From: Fiona Fitzgerald
Sent: 15 January 2018 10:36
To: Planning.Responses
Cc: Anita Gardner
Subject: WA/88/17/PL

At present, due to the issues raised above, Environmental Health would **object** to this application.

A FRONT ELEVATION
1 : 100

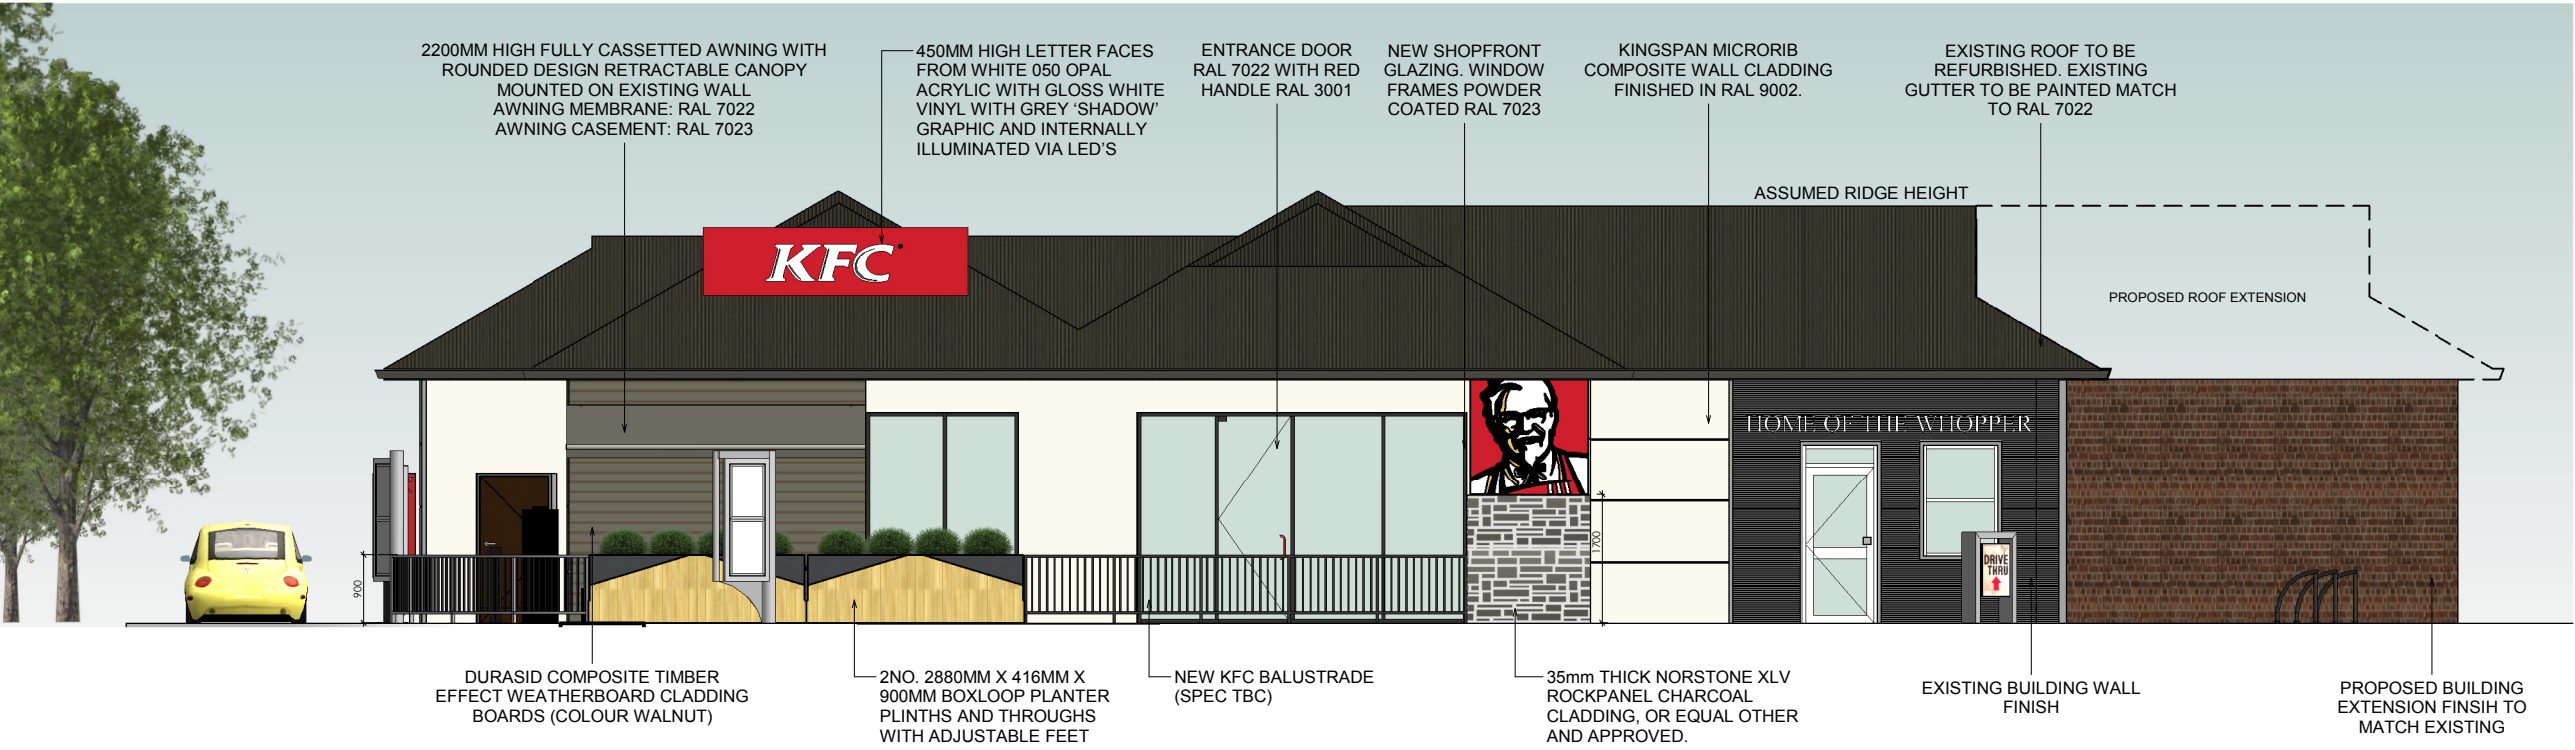
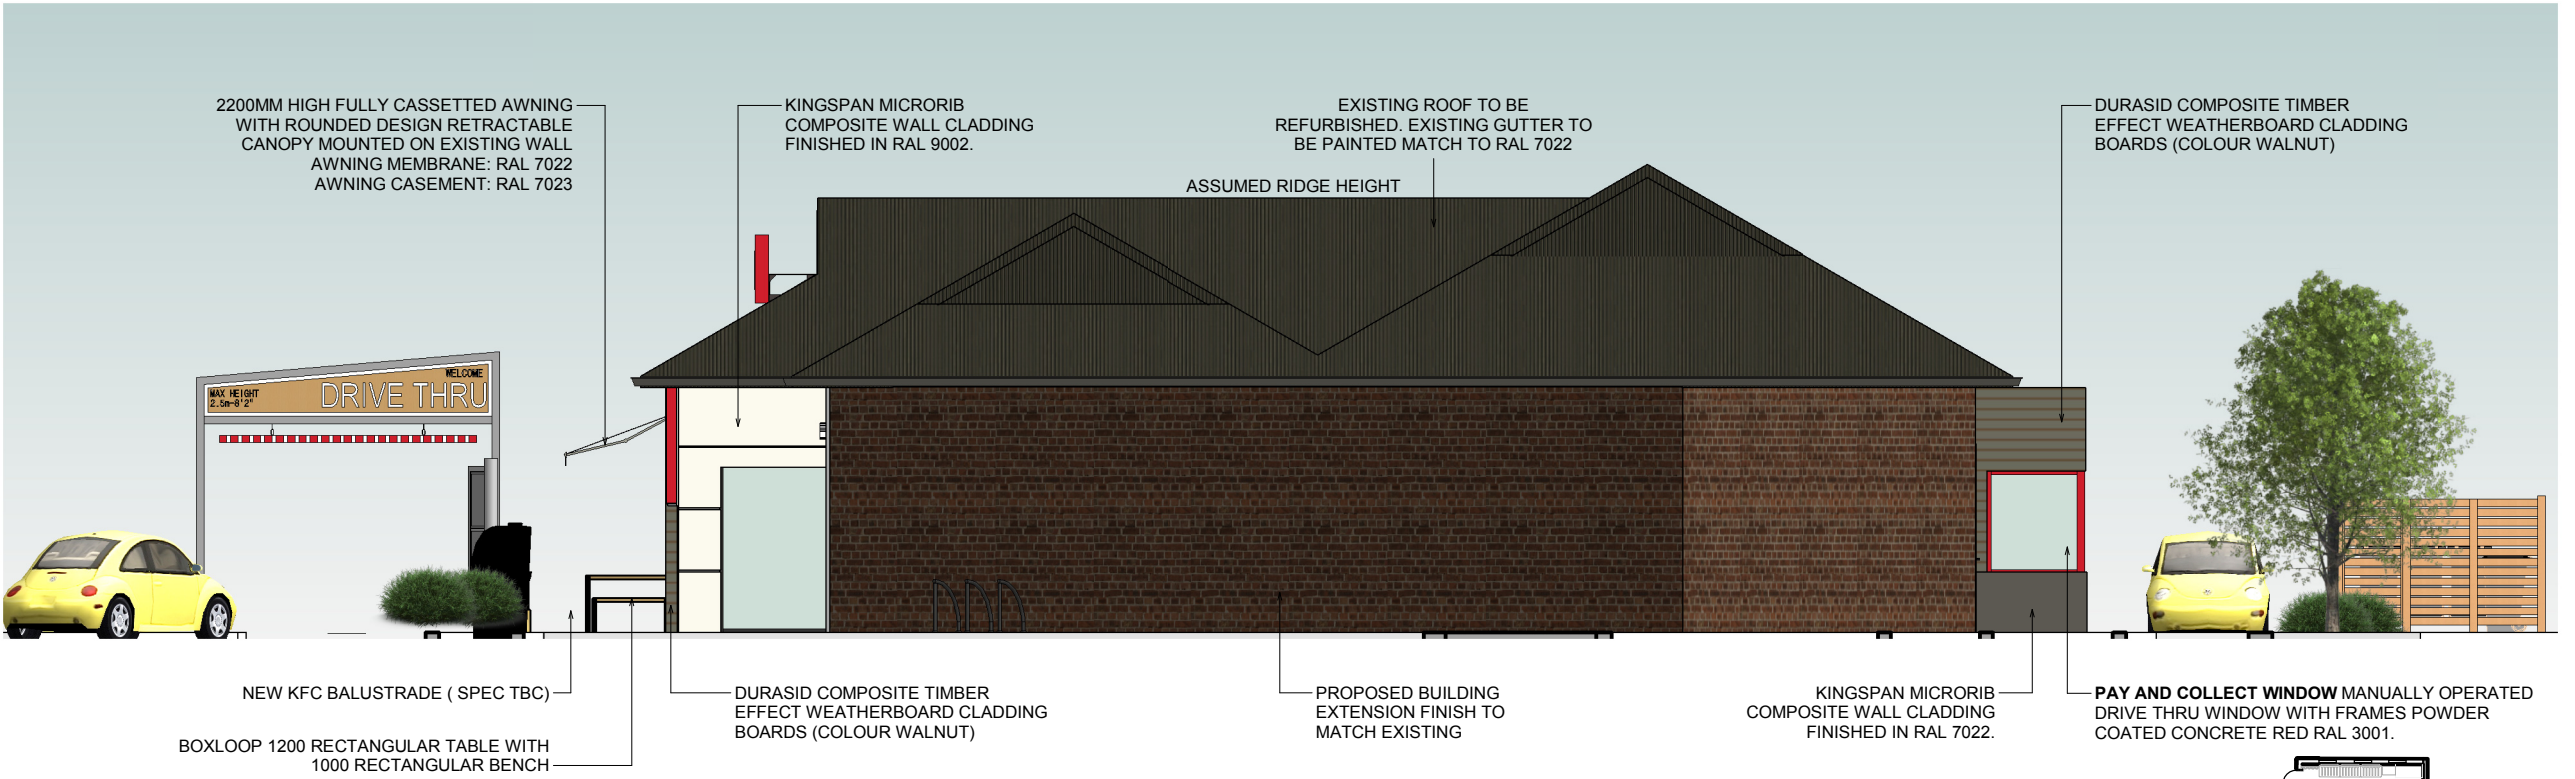
1. The application letter states “there are no proposed works to the attached Burger King unit” but the plans show a 48 sq m triangular extension. Which is correct? Is Burger King being extended or not?

1 PROPOSED GENERAL ARRANGEMENT PLAN

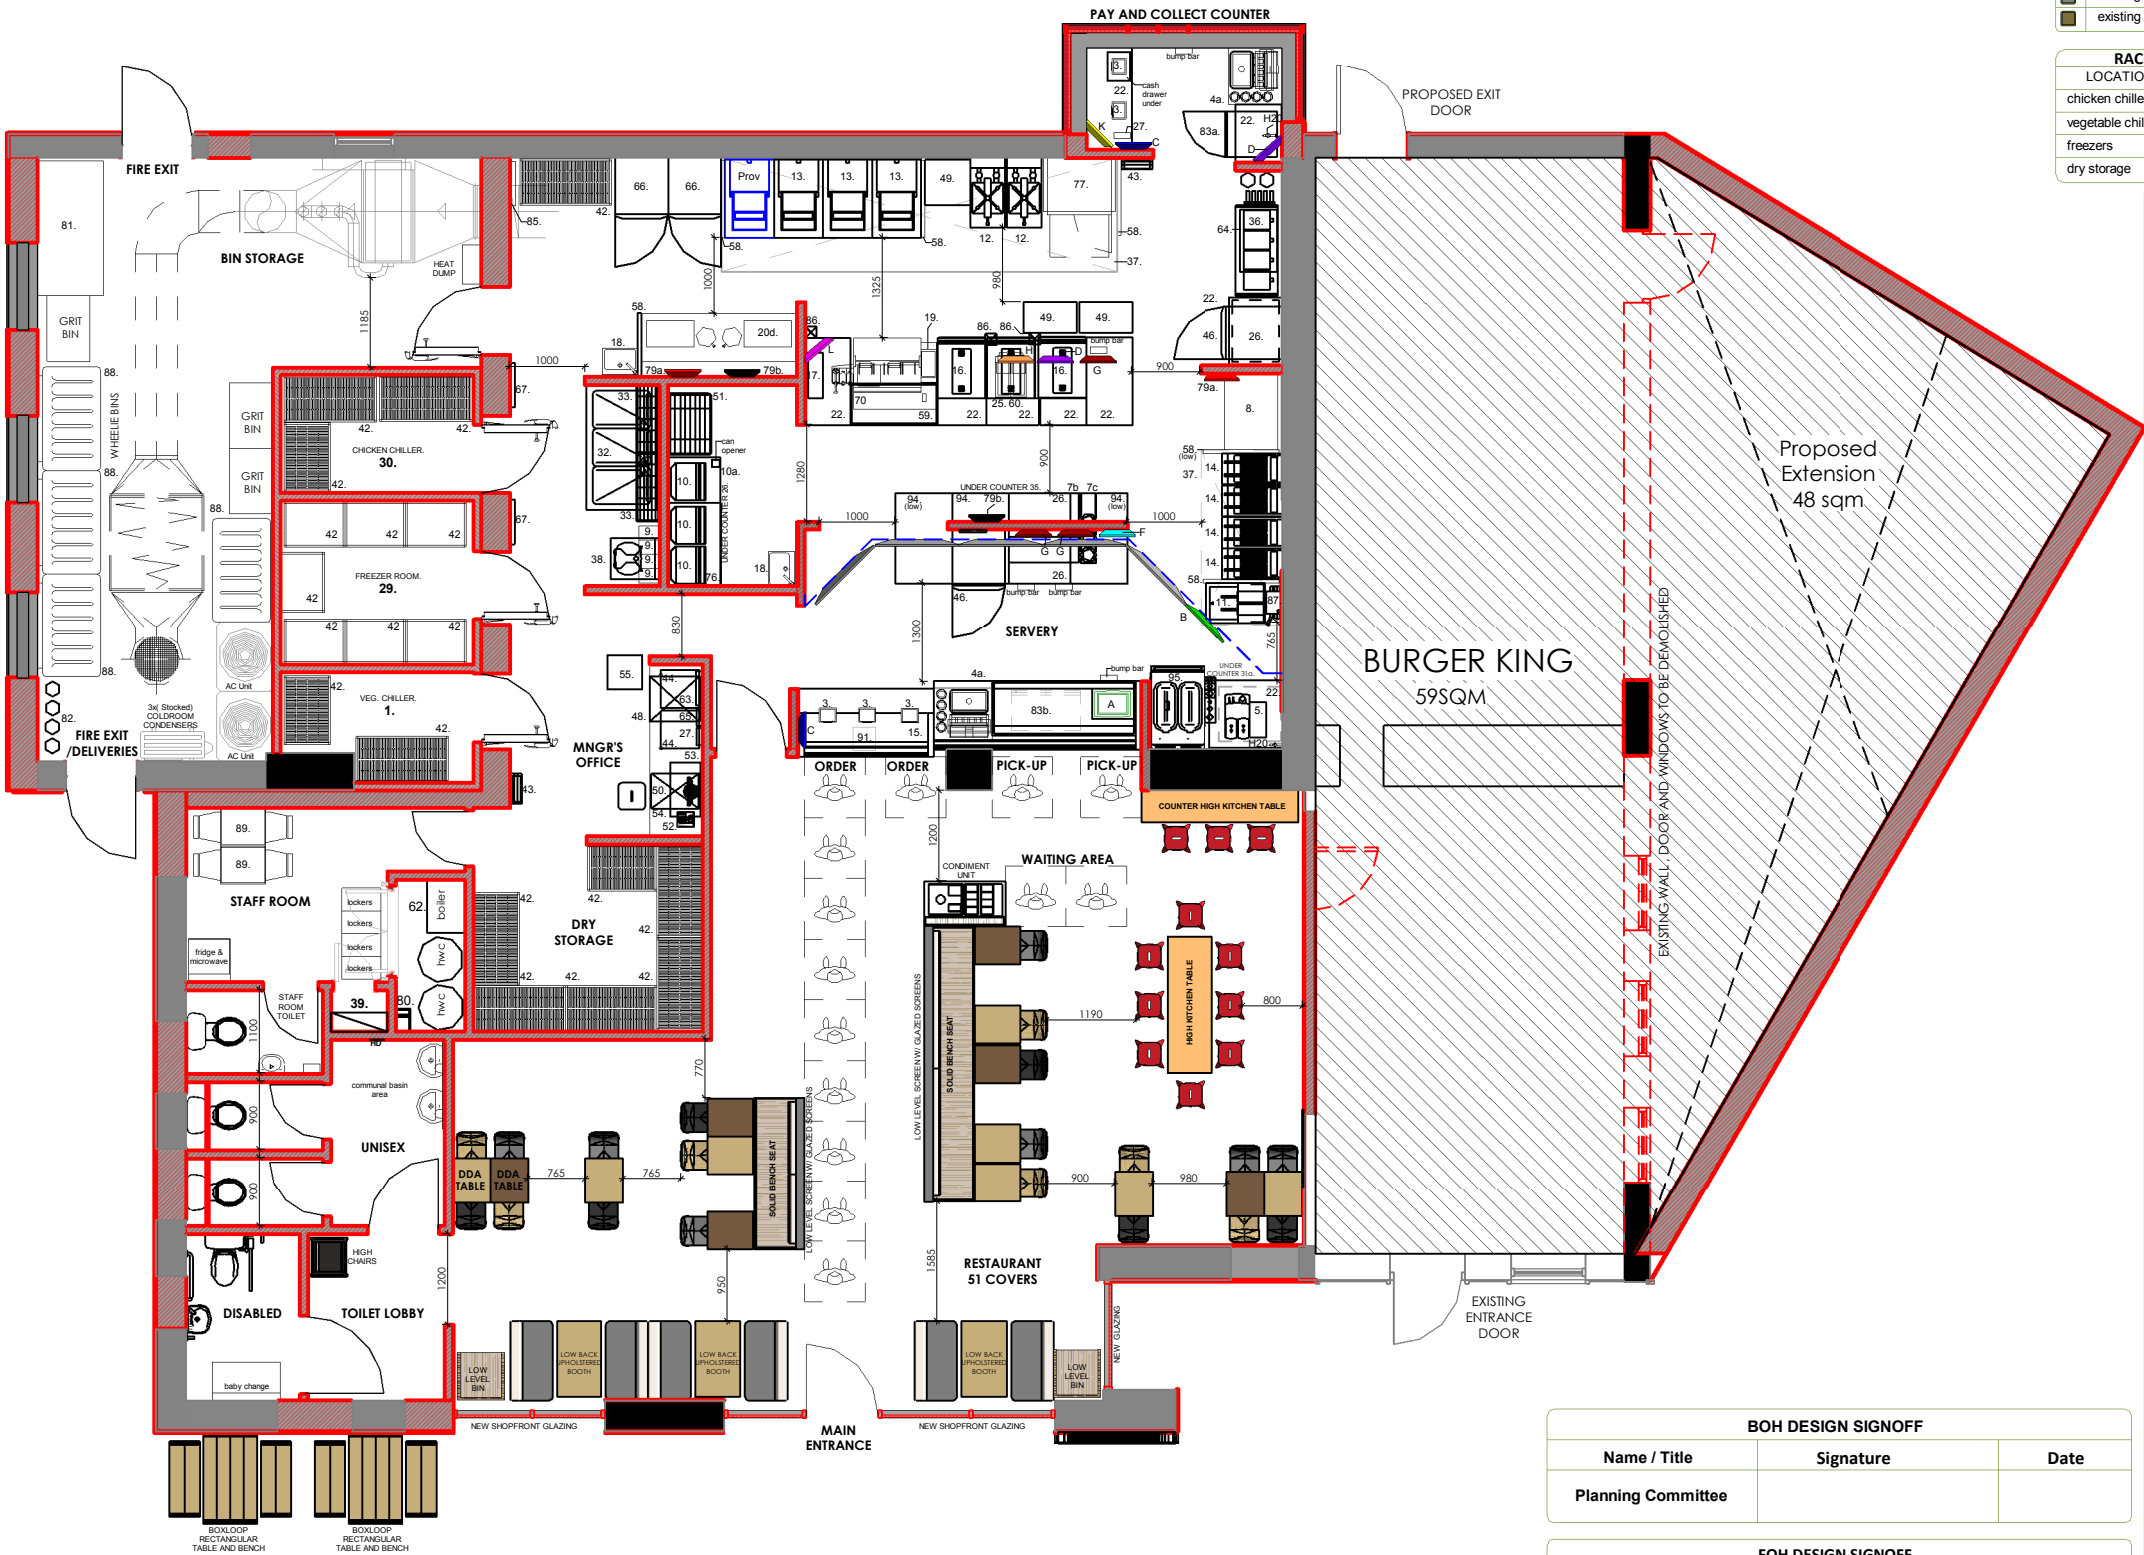
4. Can the applicant confirm whether they consider the number of wash-hand-basins in the KFC kitchen to be sufficient (2 no.).
5. Please could the applicant confirm the number of covers for this premises, so that Environmental Health can assess whether the sanitary provision is sufficient.
